1034 MCGARRY TERRACE
Urban Design Review Panel Report

Prepared for:
KTS Properties

Reference: 1034 McGarry Terrace Response to UDRP Planning Recommendations

sheet name:  
**EAST ELEVATION- WEST TOWER**

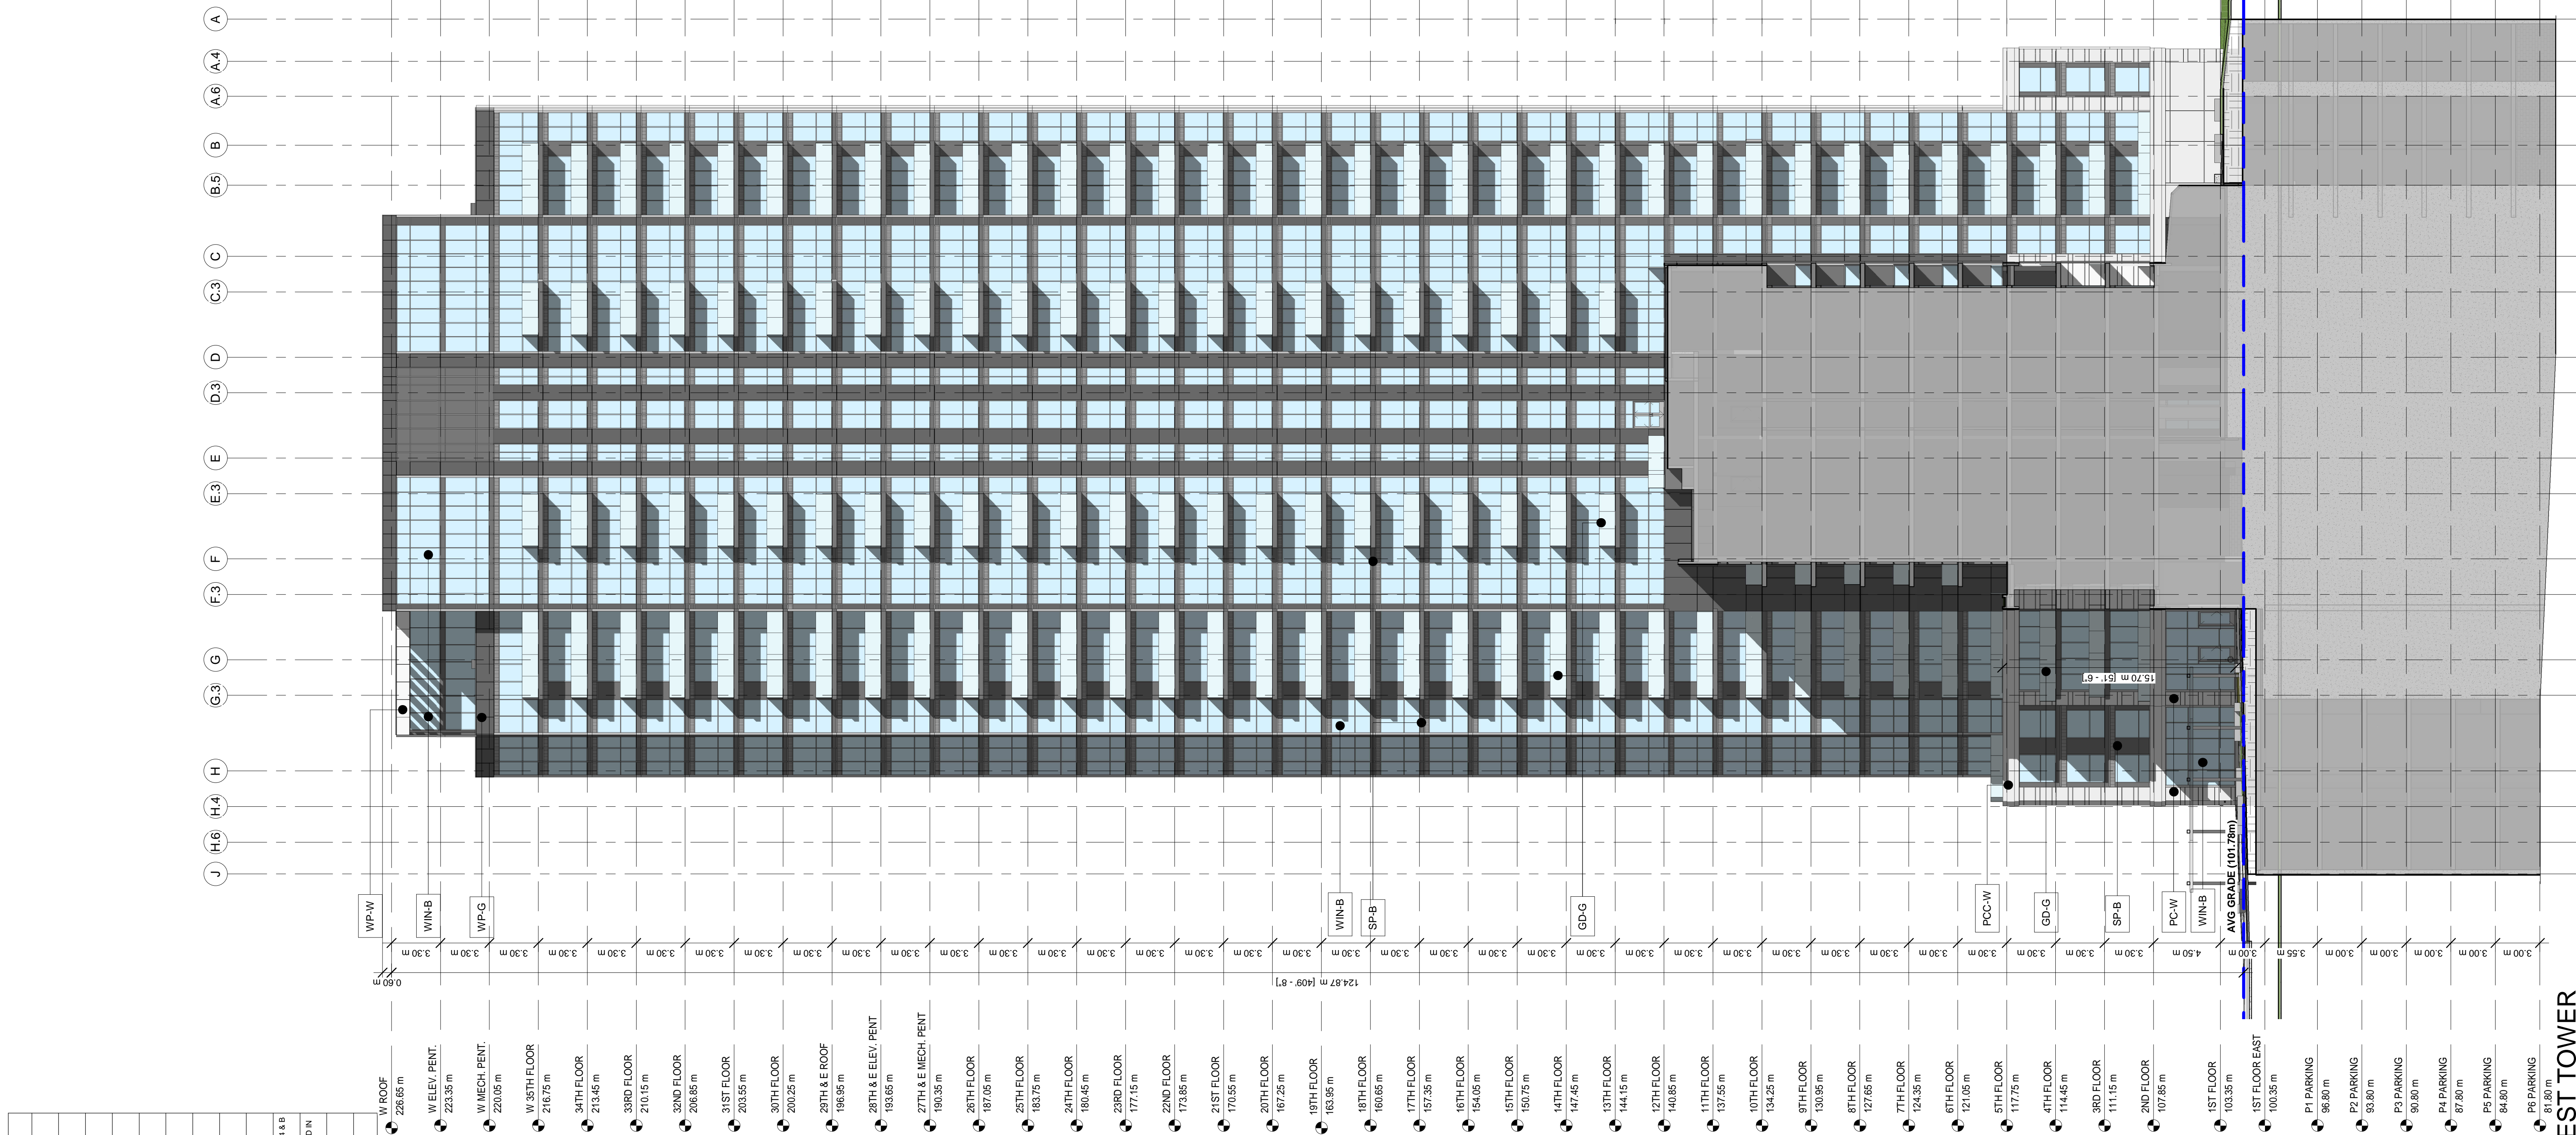
<p>The Panel has concerns with the sizes of the floorplates proposed.</p> <ul style="list-style-type: none"> • Consider reducing the floorplate sizes to help increase the separation distance between towers. • The Panel recommends designing more slender towers to foster a better quality of life for those living in the units between the two towers and help mitigate privacy concerns. • The Panel recommends reviewing the City of Ottawa Guidelines on tower separation. 	<p>The towers propose floorplates of 750 and 765 m² and are consistent with the design guidelines.</p>
<p>The Panel has concerns with the density of development being proposed.</p> <ul style="list-style-type: none"> • Is this concentration of units necessary in this area of the city? 	<p>See comment above. Barrhaven Downtown has been designated by the Official Plan, and supported by the Secondary Plan, to accommodate significant development and growth with the intent of developing into a compact, walkable, and vibrant mixed-use district.</p>

The Panel supports the current proposed massing over the previous studies shown in the presentation.	Acknowledged.
The Panel has strong concerns regarding the size of the floorplates proposed. <ul style="list-style-type: none">The Panel recommends reducing the floorplates to a maximum size of 750 square metres, as per the City of Ottawa guidelines	The towers propose floorplates of 750 and 765 m ² and are consistent with the design guidelines.
The Panel recommends investigating the possibility of a 35-metre separation between the two towers. <ul style="list-style-type: none">Consider tower separation as a remedy to wind-tunnelling and improving the micro-climate of the POPS.	Tower floorplates have been reduced to the extent feasible to increase tower separation distances and increase step-backs. Tower heights have also been reduced to reduce wind tunnelling.
The Panel recommends staggering the heights of the towers to a more appropriate scale and transition from the surrounding context. <ul style="list-style-type: none">Consider a 30-storey tower on the west side nearest to McGarry Terrace, and a shorter tower closer to 20-storeys on the east side	To ensure that there is variation in height between the two towers, it is proposed that the west tower be reduced to 35 storeys in height, whereas the east tower would be reduced to 26 storeys.

sheet name:  
**SOUTH ELEVATION**

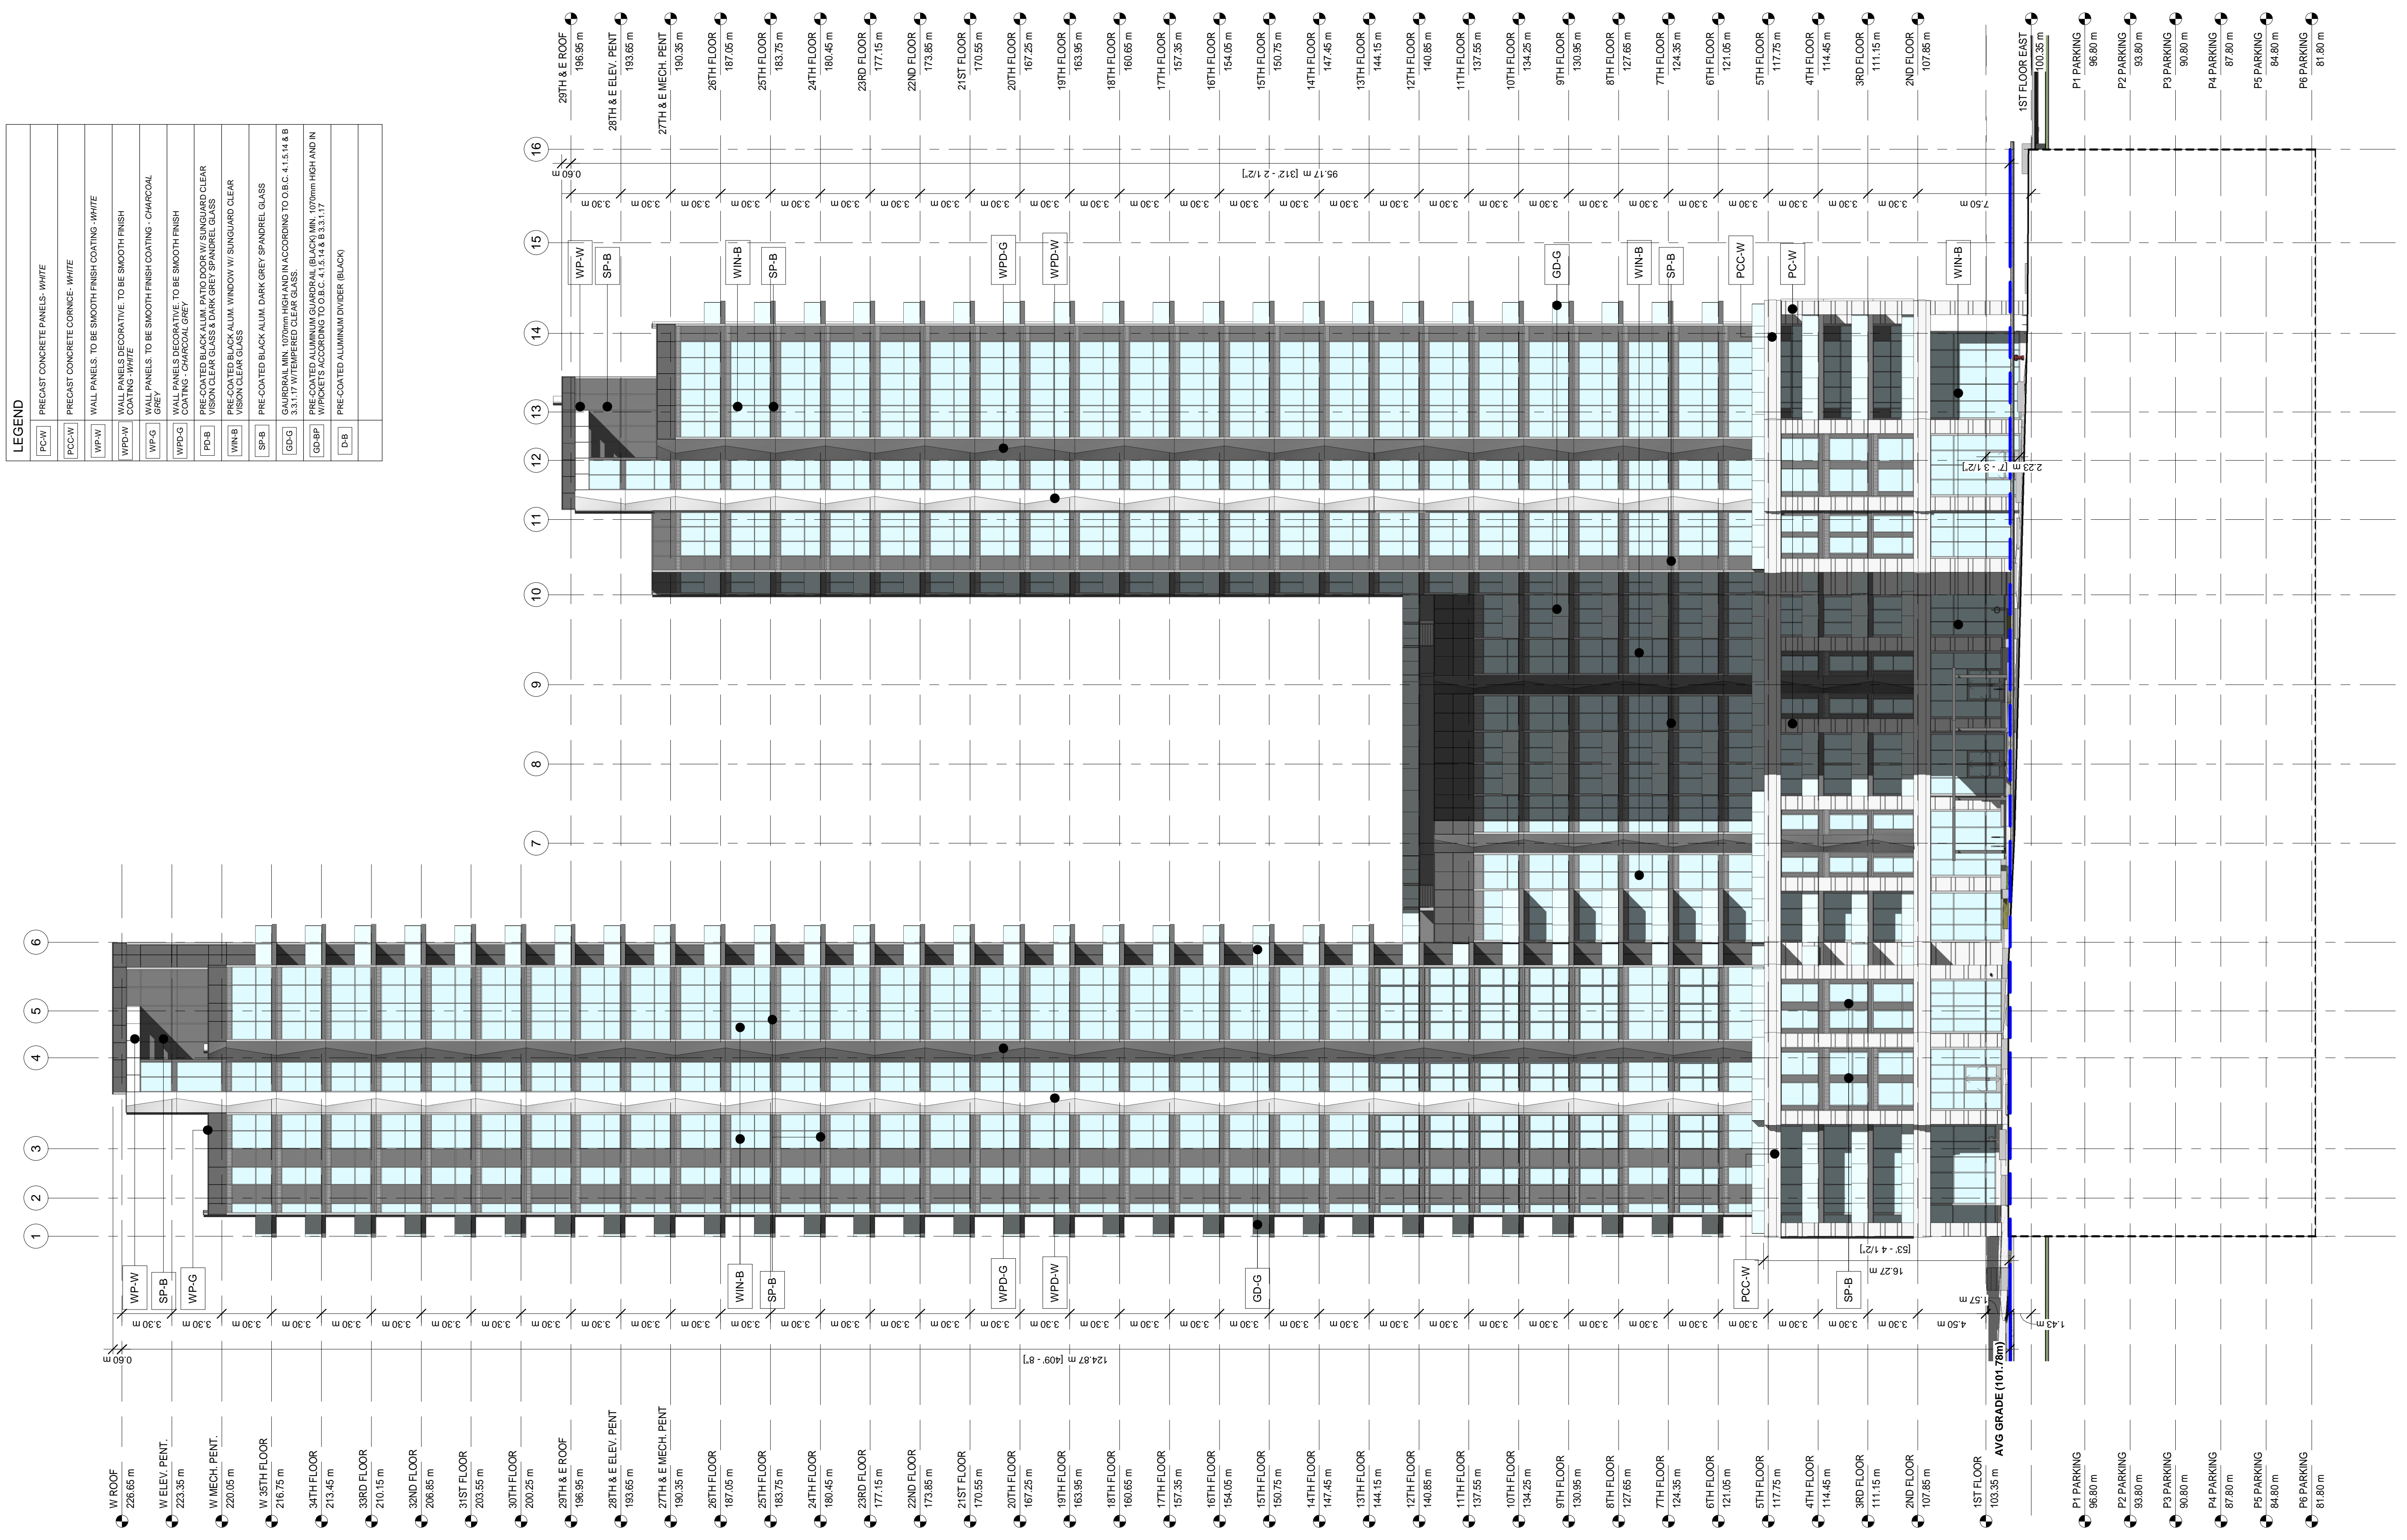
<p>The Panel recommends stepping the towers back considerably along the street frontages</p> <ul style="list-style-type: none"> • Consider a minimum 3 metre step-back above the 4-storey podium • Consider additional step-backs up the tower. 	<p>Step-backs have been provided from Marketplace Avenue and McGarry Terrace. Tower floorplates have been reduced to the extent feasible to increase tower separation distances and increase step-backs.</p>
